Application No: FP/182/20/HH
Site Address: Gulls 7 First Avenue Felpham PO22 7LG
Description of works: Single storey rear extension to replace existing conservatory with revised roof to existing single storey extension, first floor rear extensions, single storey glazed canopy to south side elevation

Thank you for your internet representation made on 15th November 2020 which has been recorded as an objection with the comments as follows:

36 Grove Road • Havant • Hampshire • PO9 1AR
Director: Martin Farrer RIBA • Co Registration No.4507379
Date: Sep 2020
Scale: 1:100
Job No: 3249
Dwg No: P_01

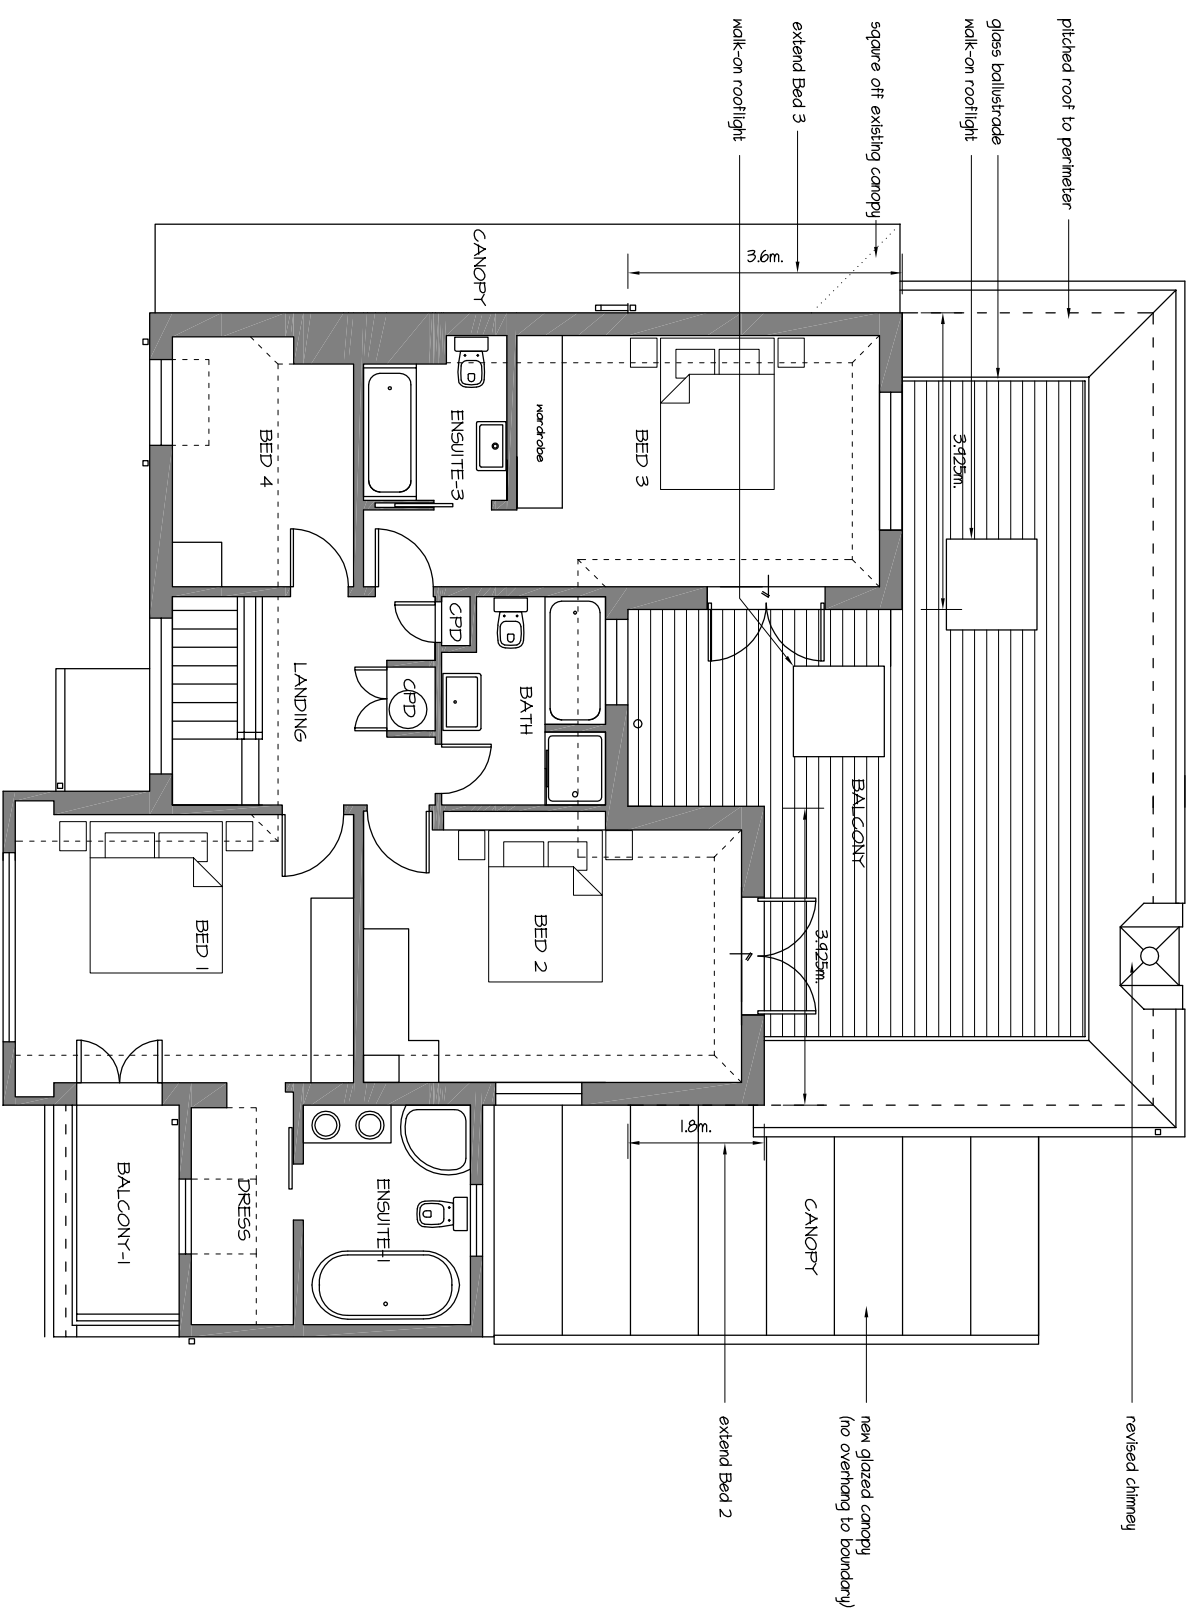
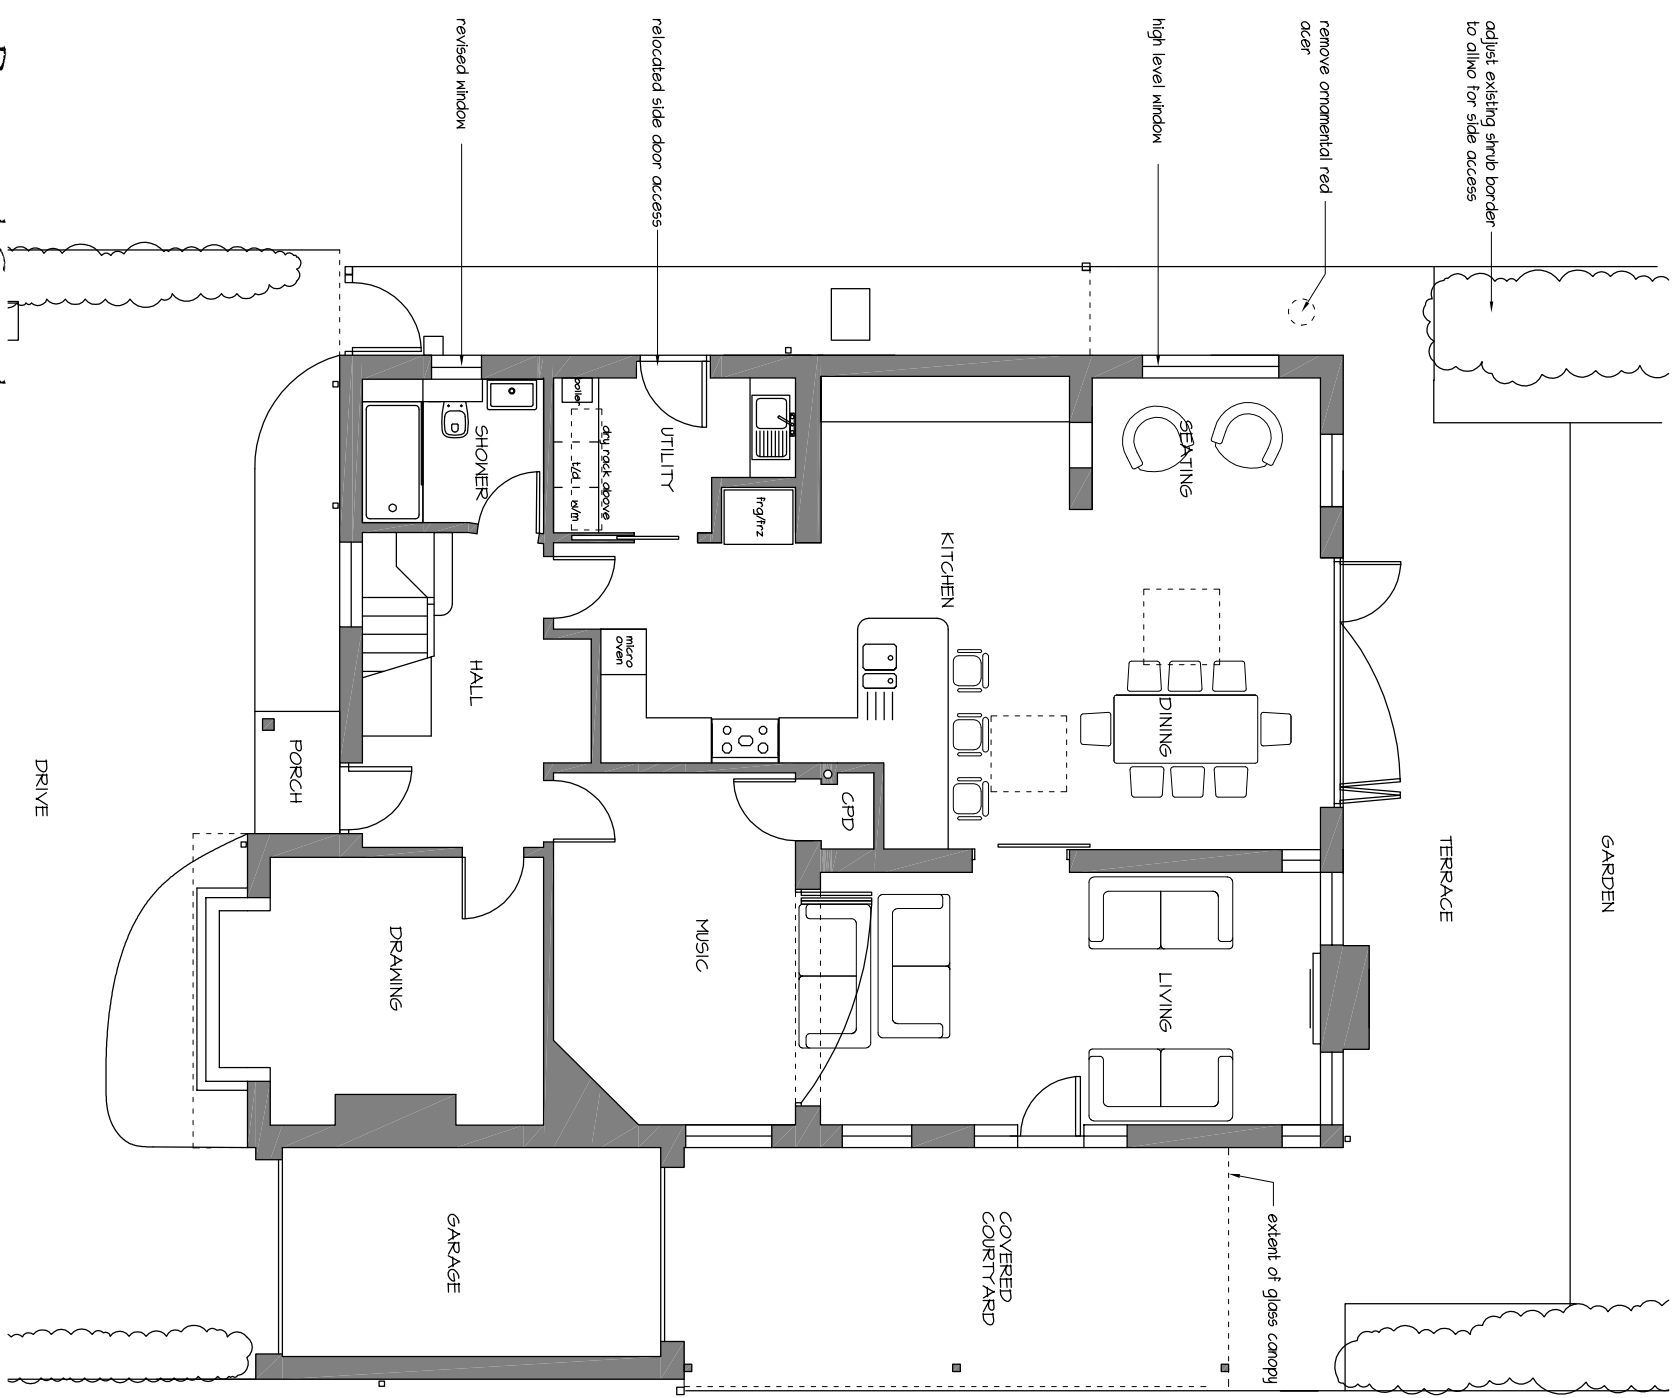
Having looked at the submitted planning application (ref FP/182/20/HH) and associated plans, I wish to place an objection on file as I believe the application contravenes Policy D DM1 of the adopted local plan. The plans indicate the construction of a first floor balcony and glazed balustrade. This balustrade on the south elevation is directly adjacent to my boundary and property and so this directly overlooks not only my garden but also directly into the living area of my house (bungalow), as I have a glazed roof on my conservatory. Given the proposed height of the balcony balustrading as indicated on plan, not only would one be able to see directly through this but anyone standing at the balcony would be able to look over and directly into my property and garden.

Job No: 3249
Dwg No: P_02

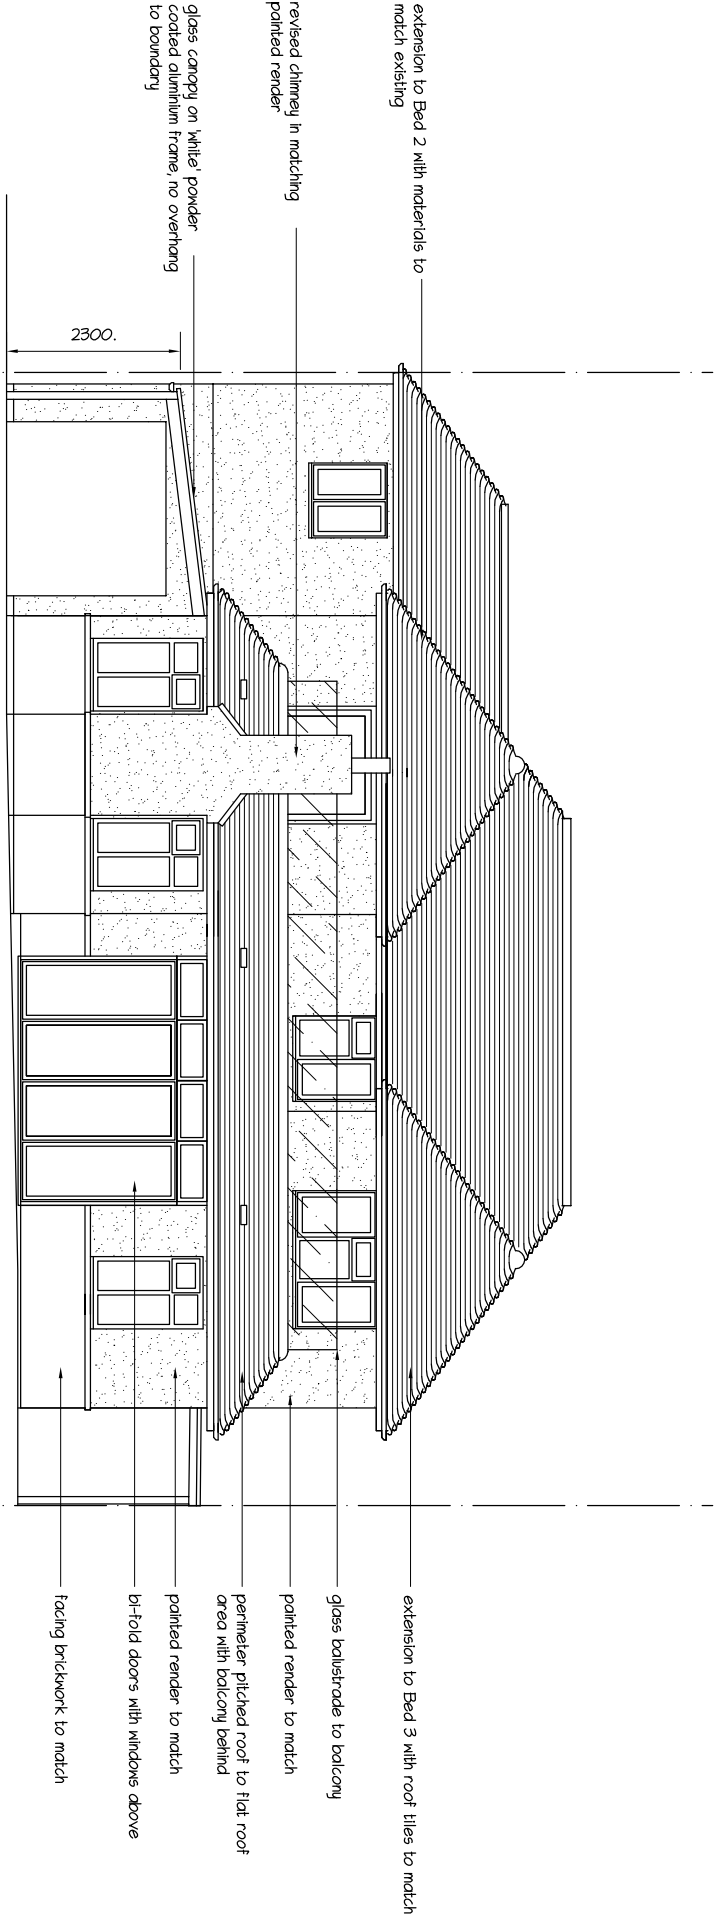
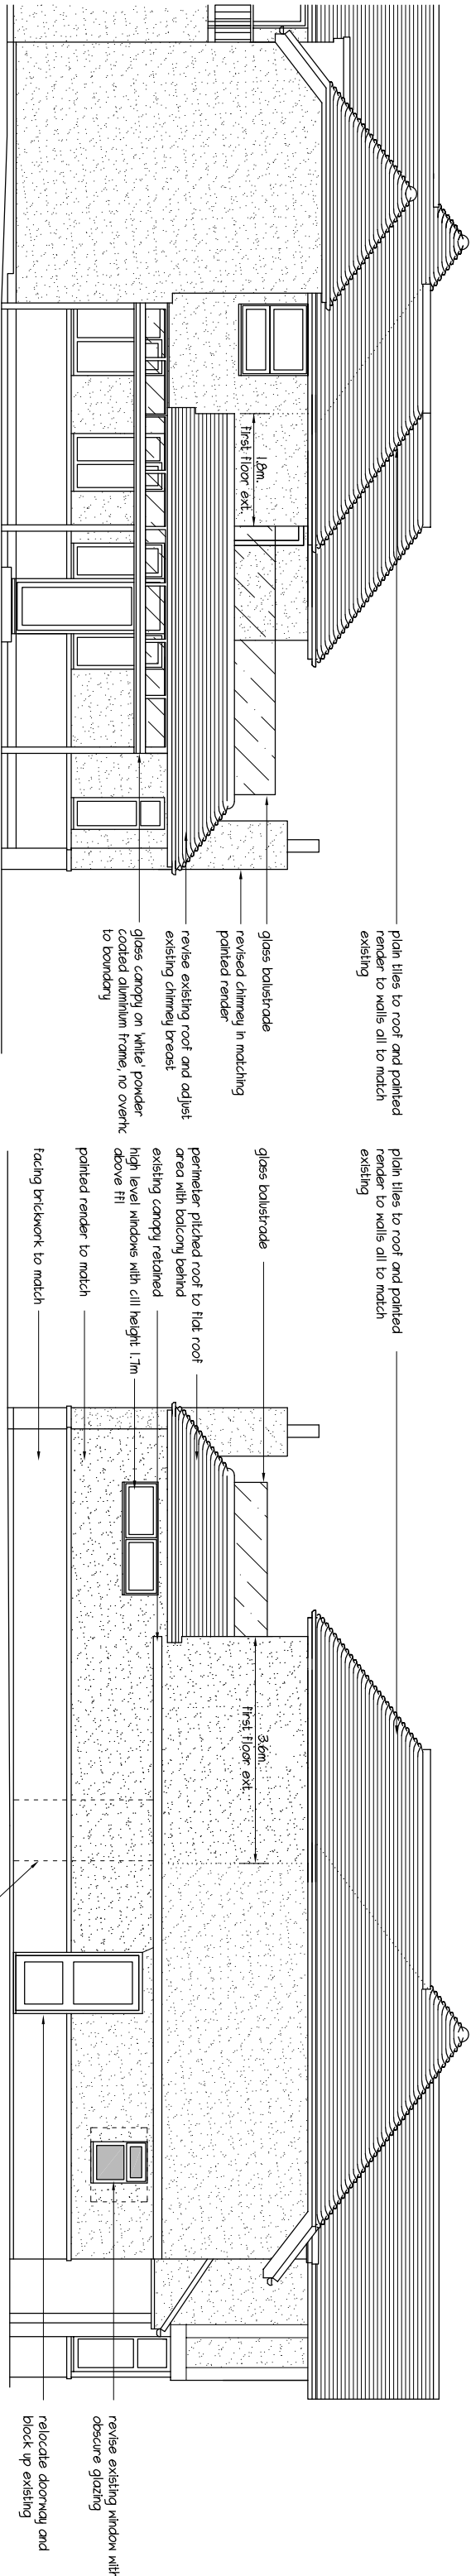
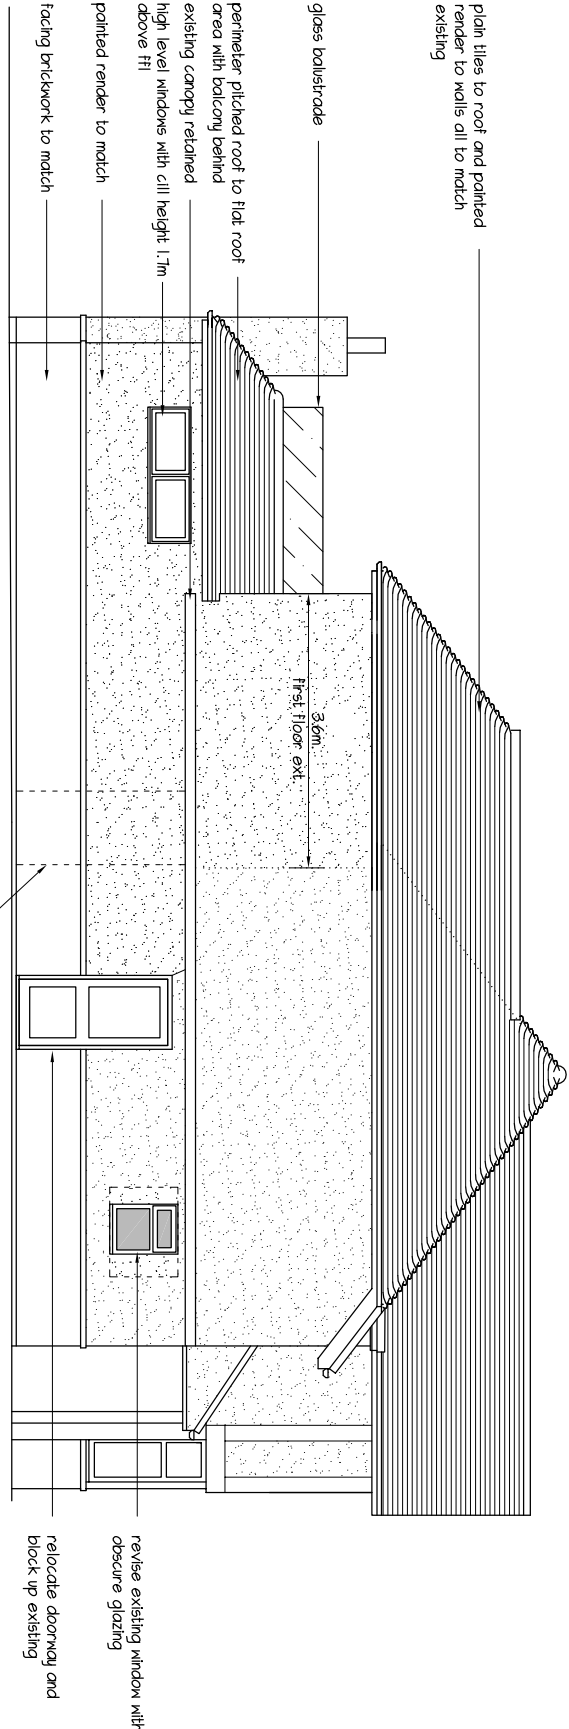
The trees present on the boundary are not protected and so may not always be there and also, are deciduous, so cannot be relied upon as reasonable mitigation for any screening.
